ENVIRONMENTAL IMPACT ASSESSMENT (EIA) SCOPING OPINION

Application: 3/2024/0893

Location: LAND OFF PIMLICO LINK ROAD

Proposal: EIA SCOPING REQUEST FOR A PROPOSED ALTERNATIVE TEMPORARY PARK AND RIDE AND HEAVY GOODS VEHICLE (HGV) MARSHALLING AREA.

FIGURE 3

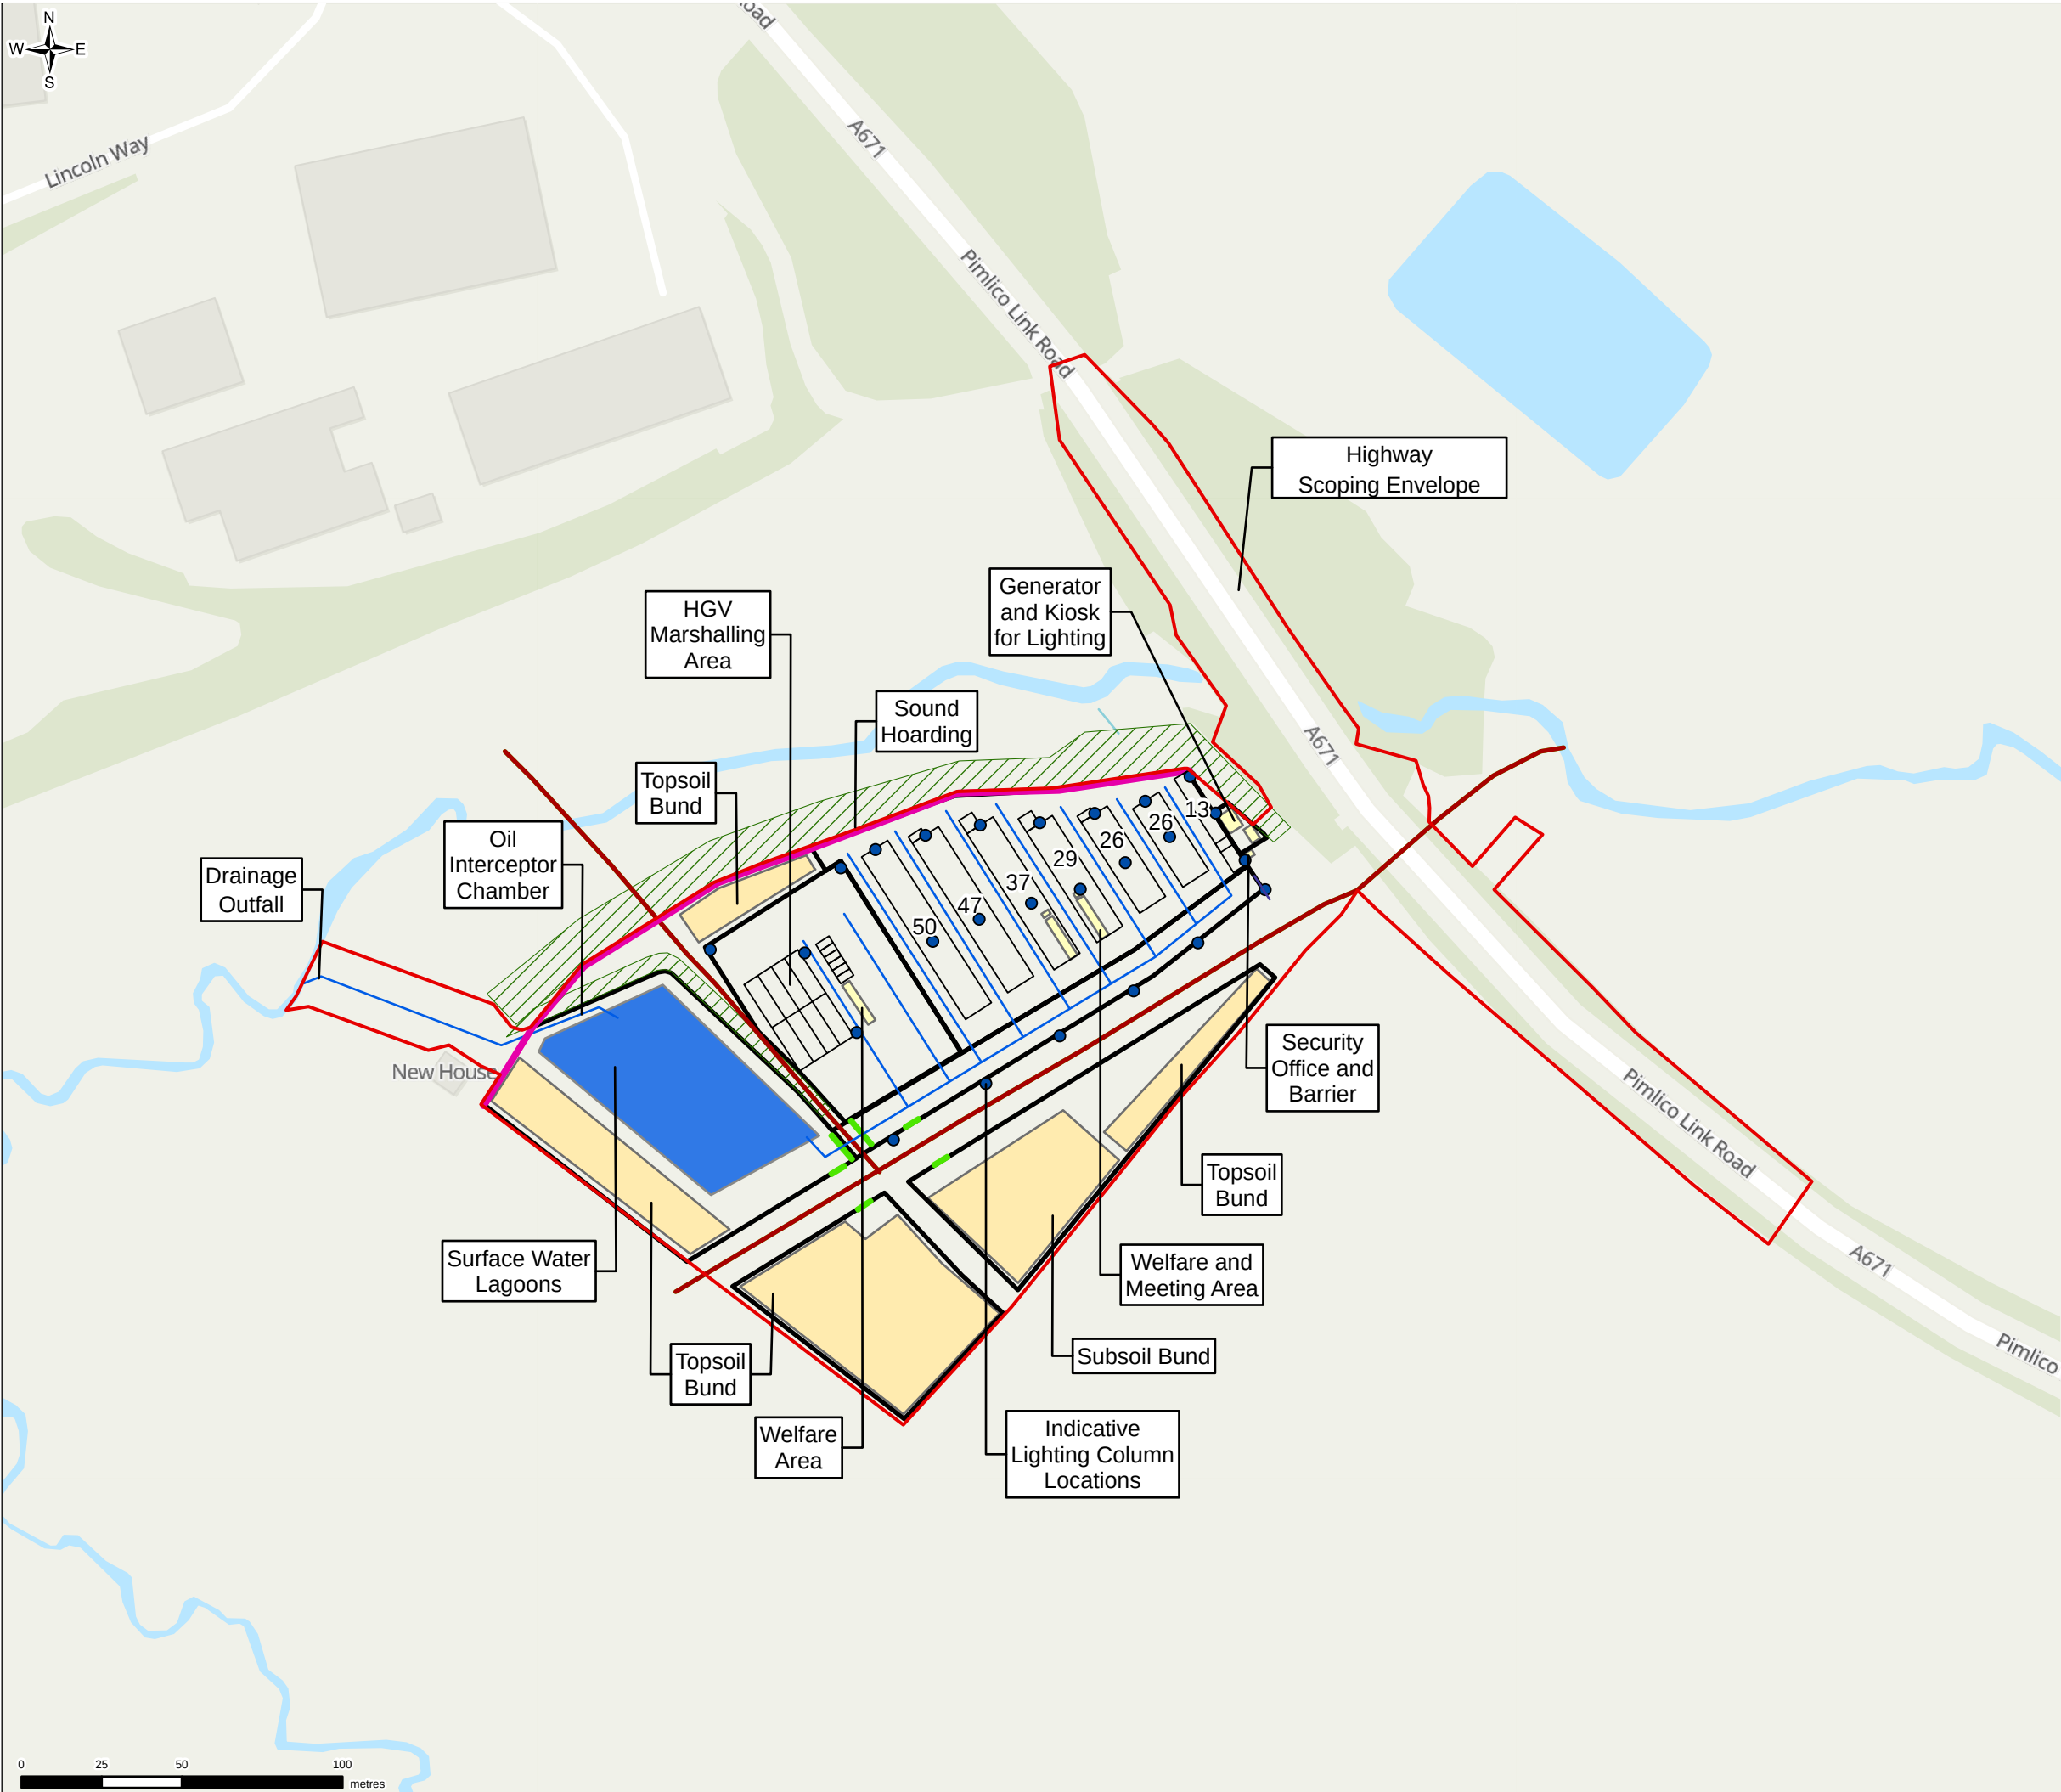
The request for a formal scoping opinion is supplemented with an EIA Scoping Report, produced by Jacobs, dated October 2024. The EIA Scoping Report sets out the proposal for an alternative Temporary Park and Ride and Heavy Goods Vehicle Marshalling Area. The indicative layout of the alternative park and ride and HGV marshalling area is shown in Figure 3 of the report and the approach to transport planning is also set out in the report.

The proposed application is to relocate the proposed HARP HGV marshalling area from the current permitted location. It is expected that the proposed access will need to consider practicalities of access arrangements to demonstrate that the routes and access are safe and workable for all modes and all movements. Where necessary, mitigation measures will need to be developed to address identified impact. It is important that the TS identifies the expected changes in HGV numbers on the approved routes.

I would expect the TS to identify any potential impacts to pedestrian safety and suitable mitigation if required. There is a Public Rights of Way (PROW) that runs adjacent to the proposed site and at the proposed access. I would expect to see full assessment of any proposals that impact existing PROW and associated mitigation measures.
